Re. Walmart #835.275 located at: 400 Eubank Blvd NE – PR2

The scope of work for this Administrative Amendment re\view is the for updating of the previous AA#-**SI-2022-00847** for the Walmart building/site signage along with the gas canopy & building to the new updated font and new branding signage.

WALMART STORES, INC. STORE NO. 0835-275	06/02/22
PROJECT: ALBUQUERQUE, NM	PLAN REVISION #2
PROJECT NO. 21694016

Description: This Plan Revision consists of Drawing Sheets **A2 and A2.1** dated **06/02/22**. No specification changes.

EXTERIOR ELEVATIONS
 SHEET: **A2**

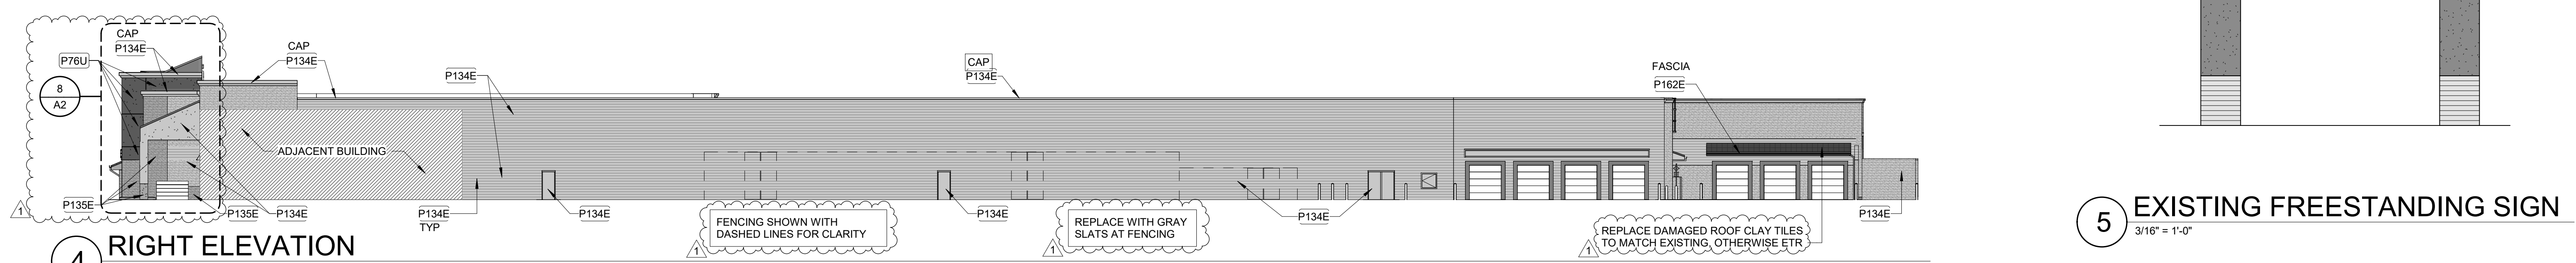
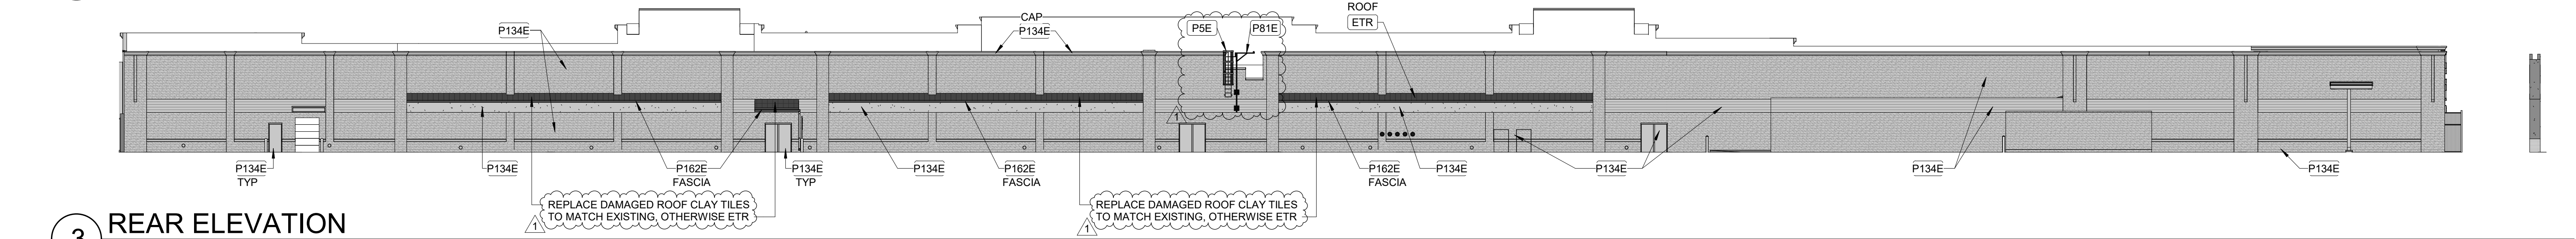
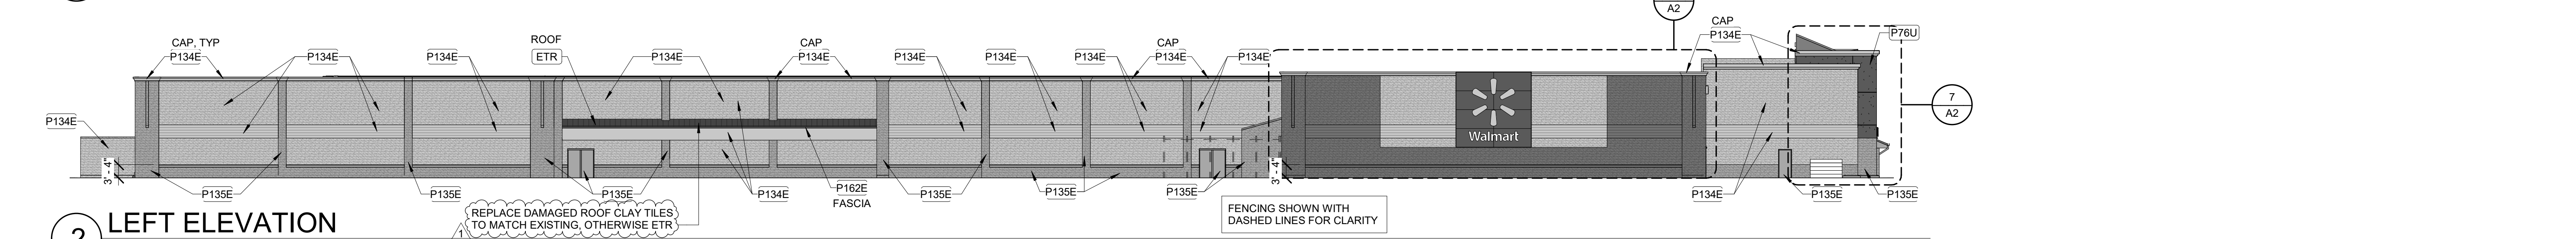
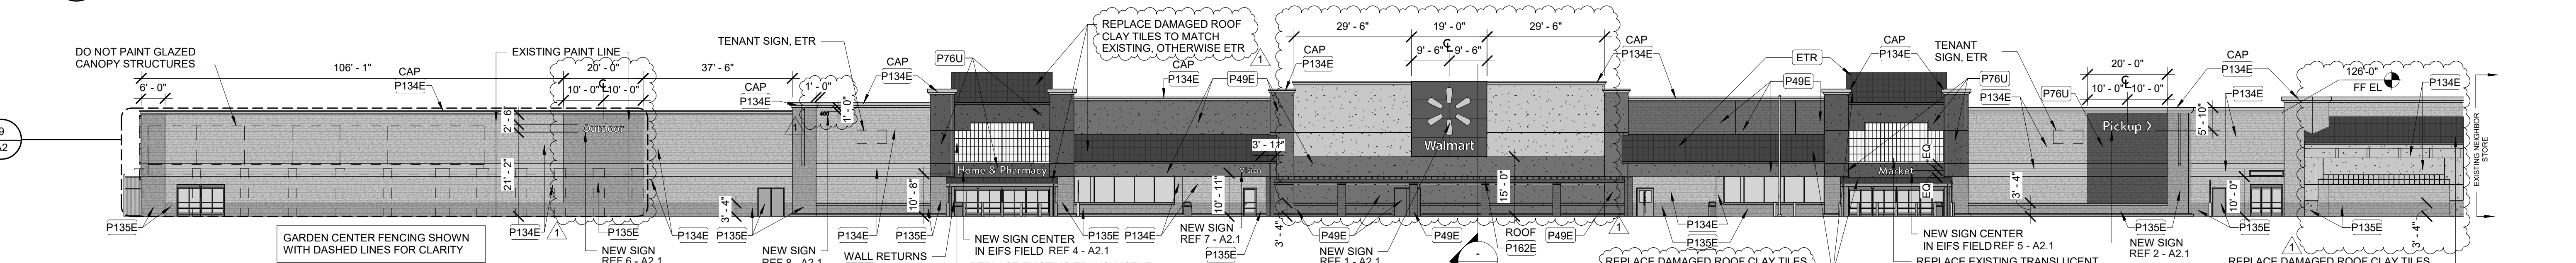
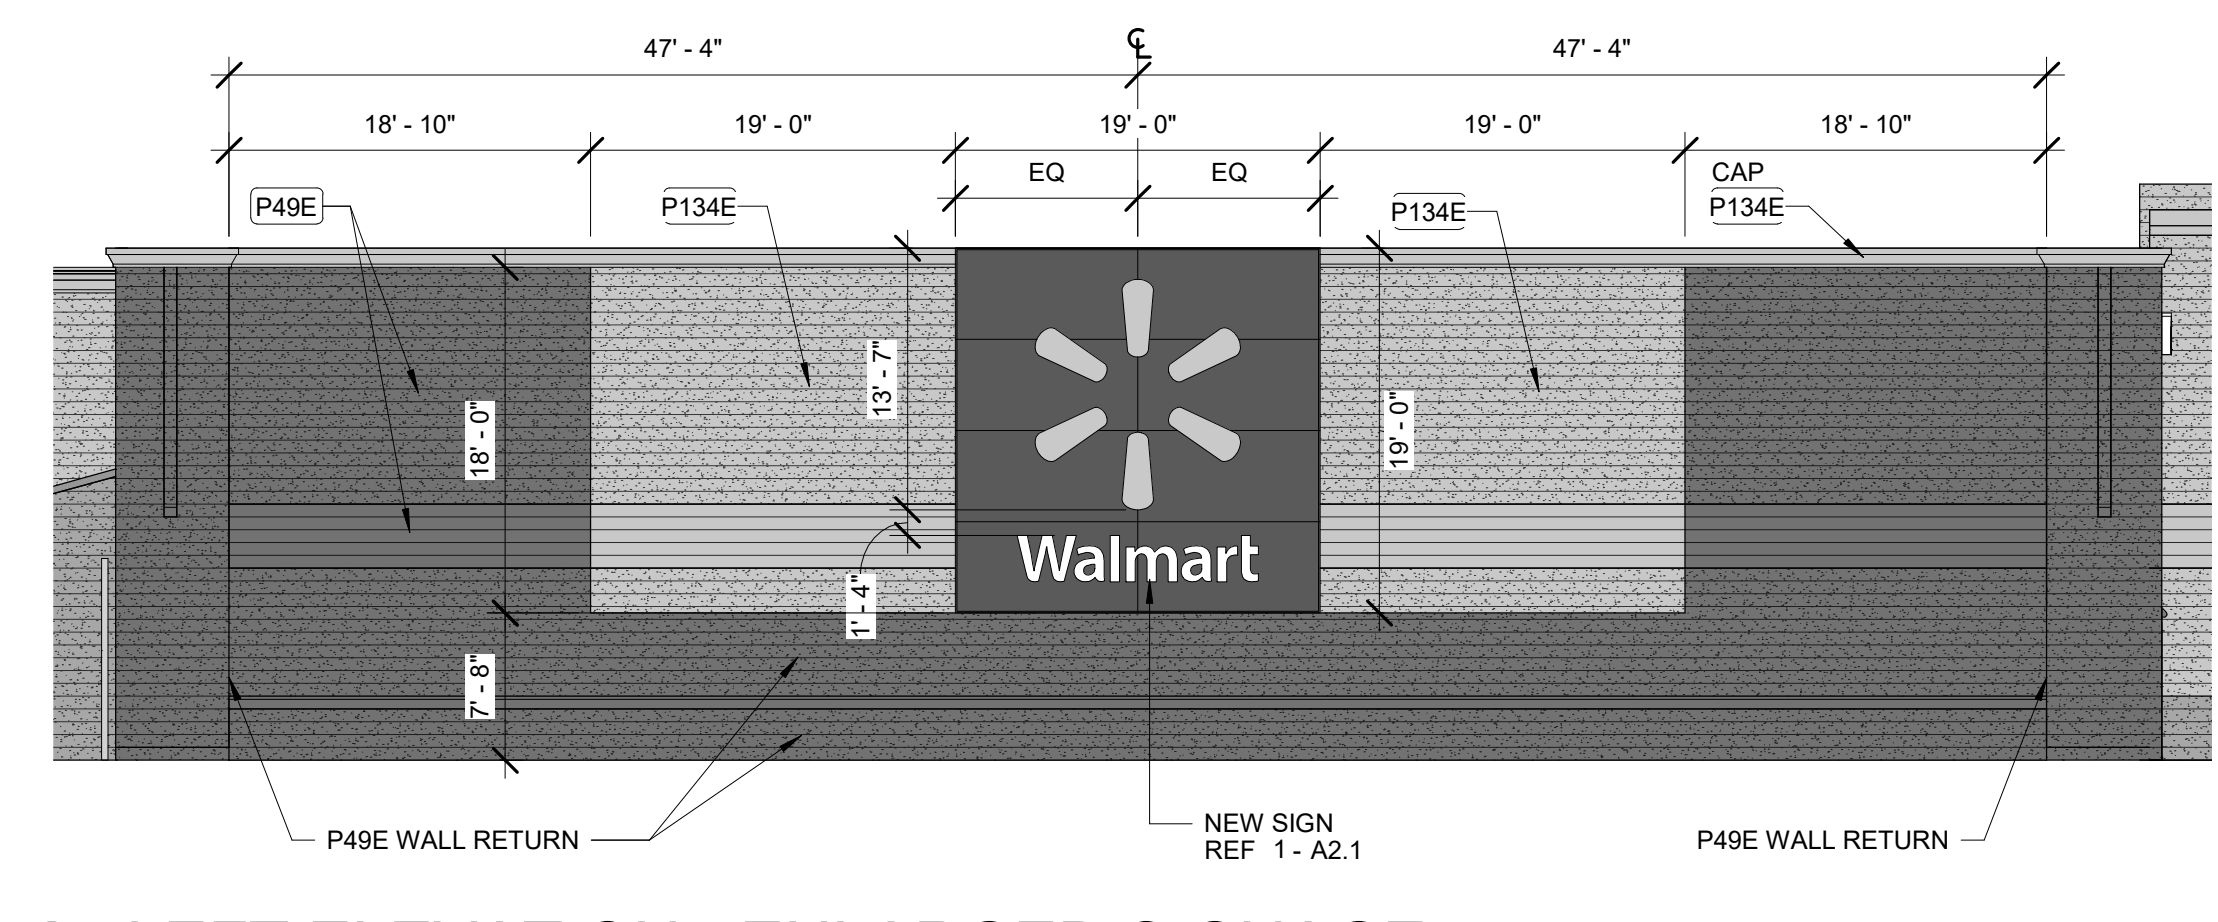
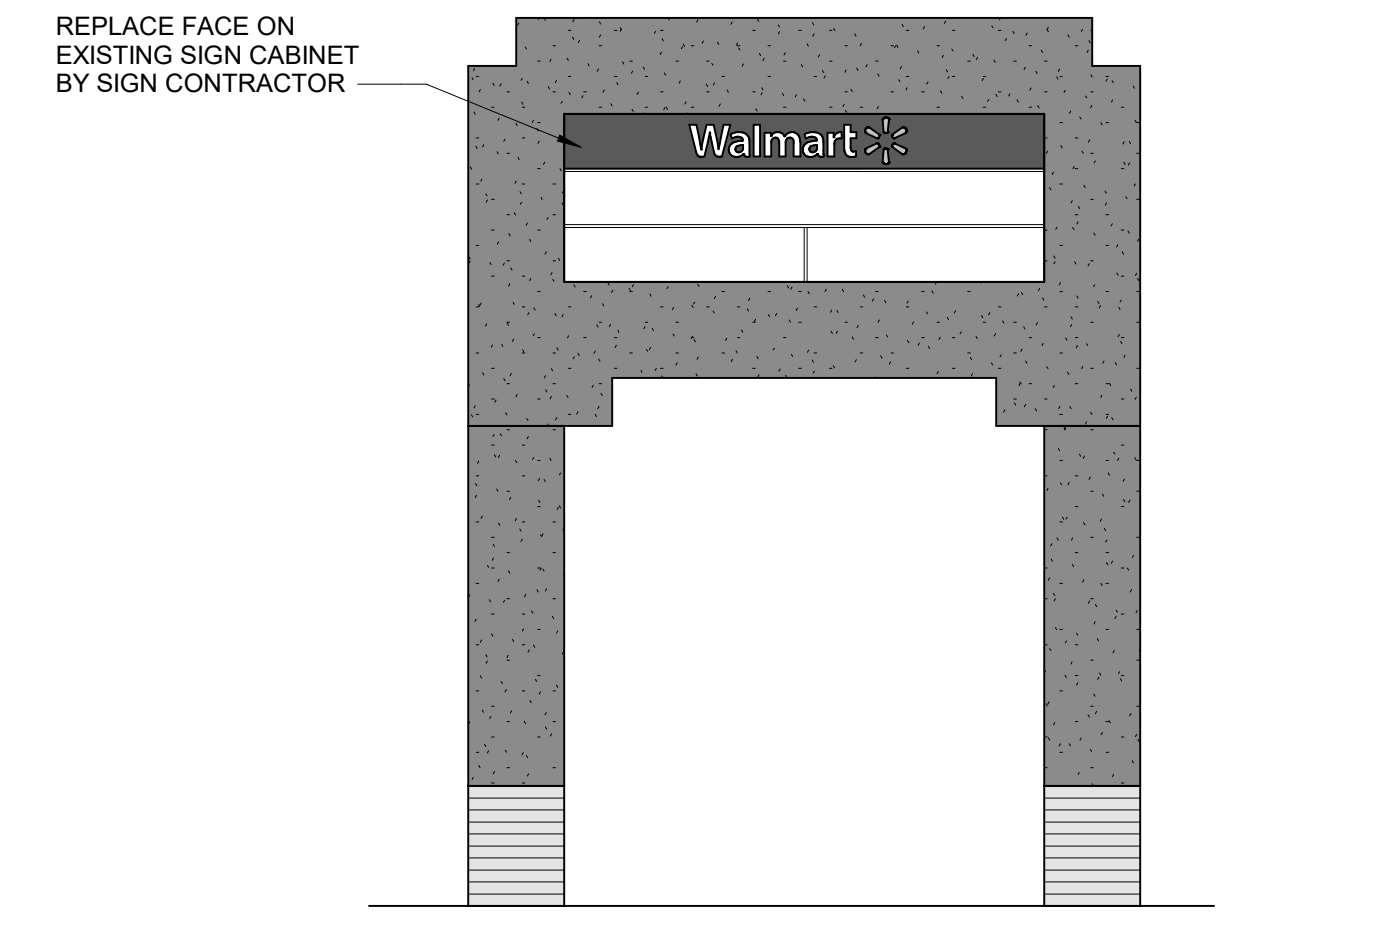
SHEET A2 – EXTERIOR ELEVATIONS

DETAIL 1 – FRONT ELEVATION

1. Revise location and paint extents at Outdoor sign. **(CI1)**
2. Relocate address sign with associated dimensions. **(CI1)**
3. Add note for clay tile scope of work at entrances. **(CI1)**
4. Revise extents of P134E at main badge **(CI1)**
5. Graphically add covered walkway to elevation and add associated notes. **(CI1)**

DETAIL 2 – LEFT ELEVATION

1. Add note for clay tile scope of work. **(CI1)**

DETAIL 3 – REAR ELEVATION

1. Add note for clay tile scope of work. **(CI1)**
2. Add paint keynotes as noted. **(CI1)**

DETAIL 4 – RIGHT ELEVATION

1. Graphically add covered walkway to elevation. **(CI1)**
2. Add note about fencing clarification. **(CI1)**
3. Add note for slat replacement. **(CI1)**
4. Add note for clay tile scope of work. **(CI1)**

DETAIL 7 – GR VESTIBULE SIDE ELEVATION

1. Add paint finish as noted. **(CI1)**

DETAIL 8 – GM VESTIBULE SIDE ELEVATION

1. Add paint finish as noted. **(CI1)**

DETAIL 9 – GARDEN CENTER

1. Add elevation to sheet. **(CI1)**

SHEET NOTES

1. Revise note 10. **(CI1)**
